## Department of Planning and Environment

**Subject: Request for Advice: Greenwich Hospital Redevelopment - Detailed Design (SSD-13619238)**

**Attachment A:** EHG Comments for Greenwich Hospital Redevelopment - Detailed Design (SSD-13619238)

Appendix E - 7 Proposed 1% AEP Peak Depth

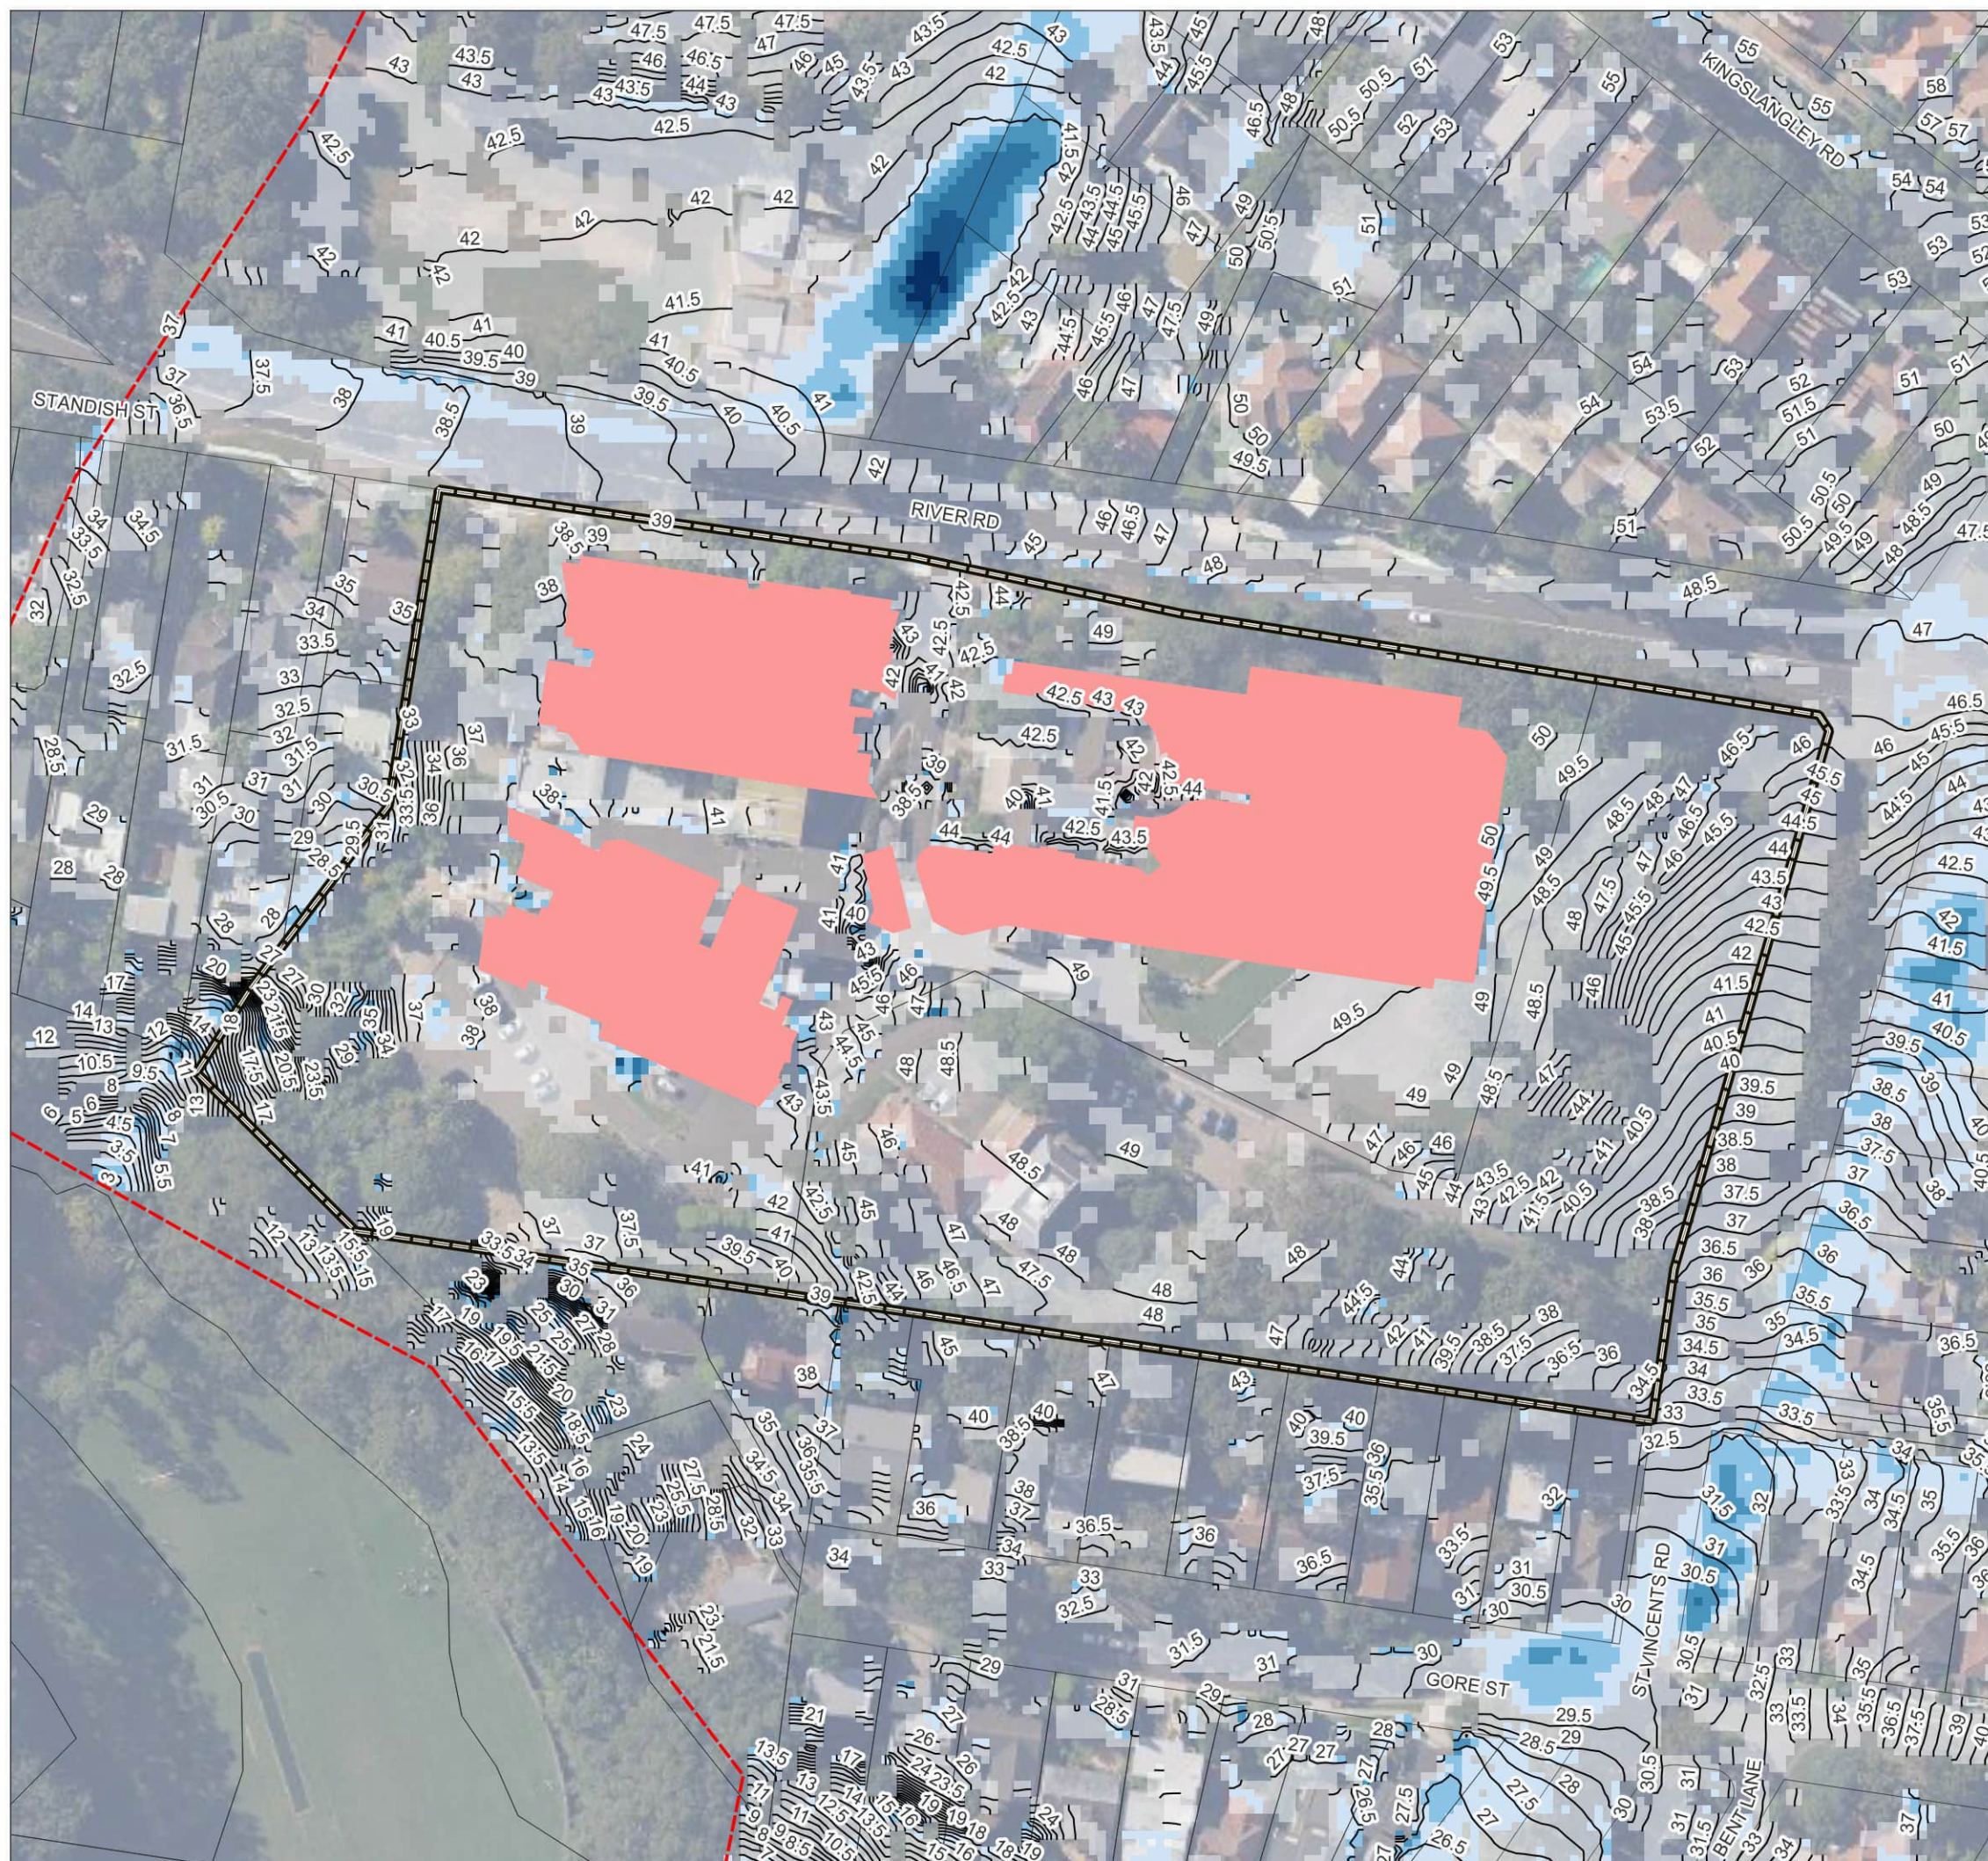
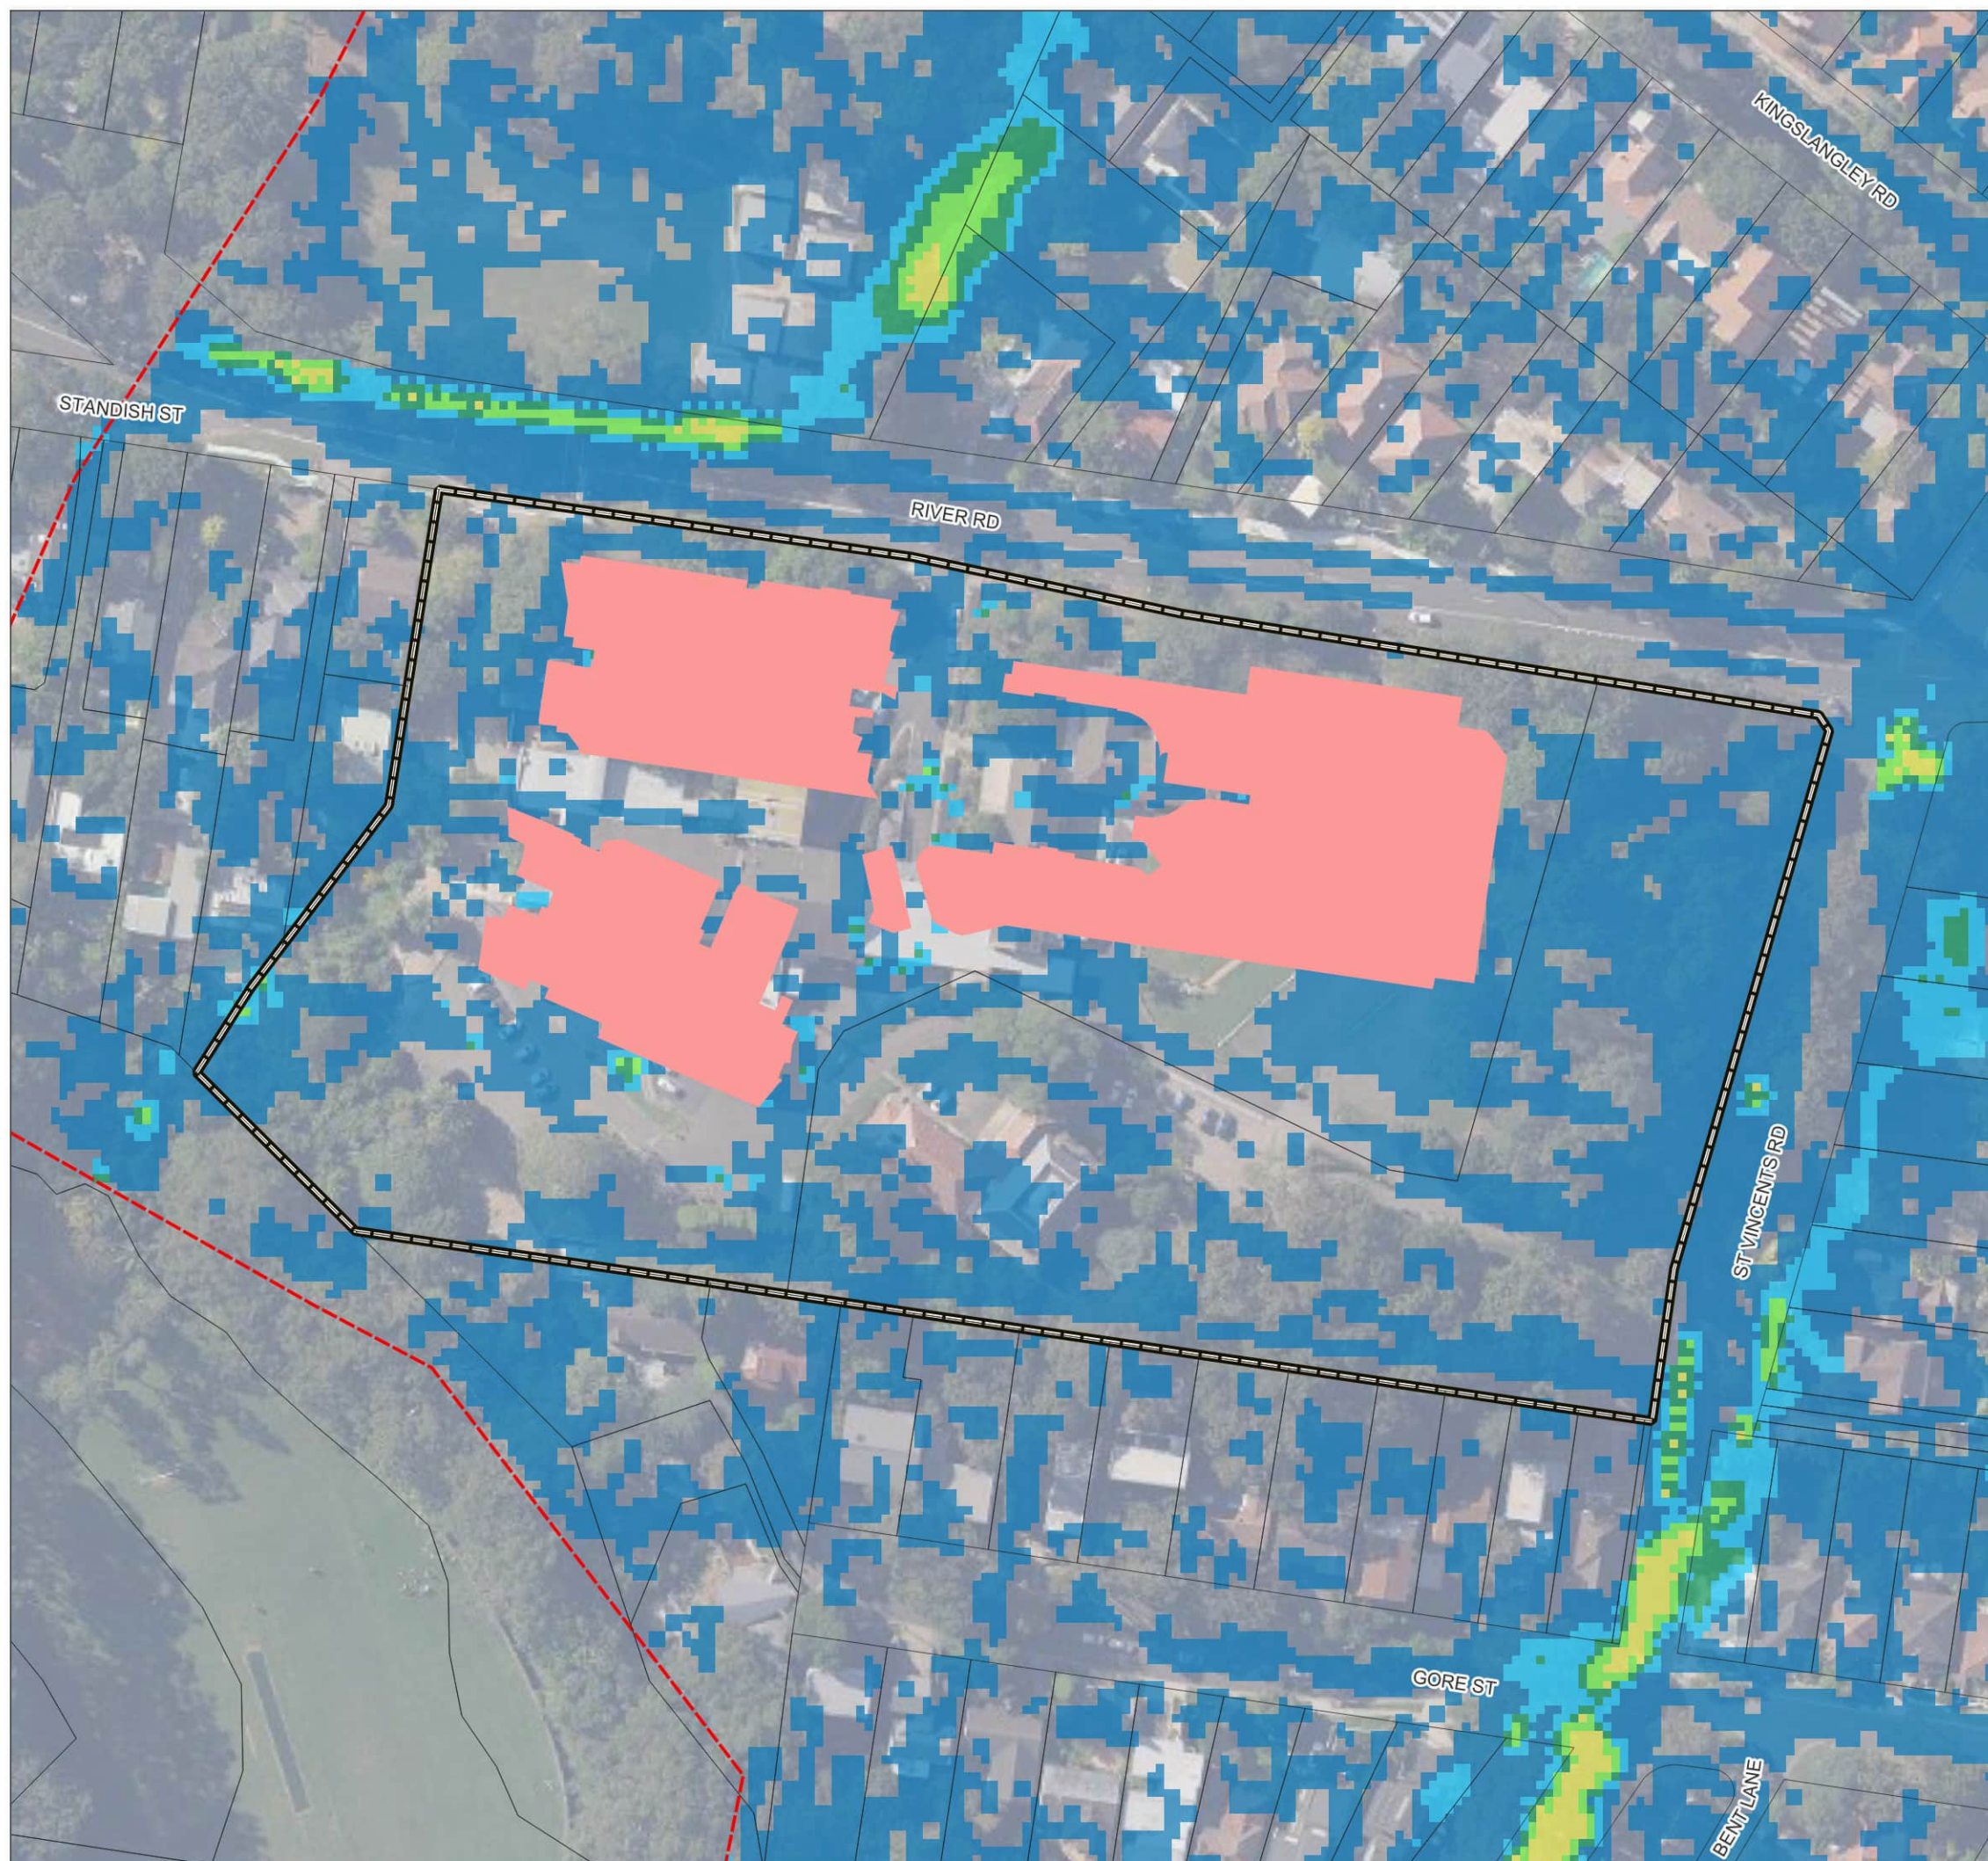
EHG also notes that the flood assessment - Appendix E provided a map of the 1% flood impact assessment, but there is no such map for the probable maximum flood (PMF) event. This mapping should be provided.
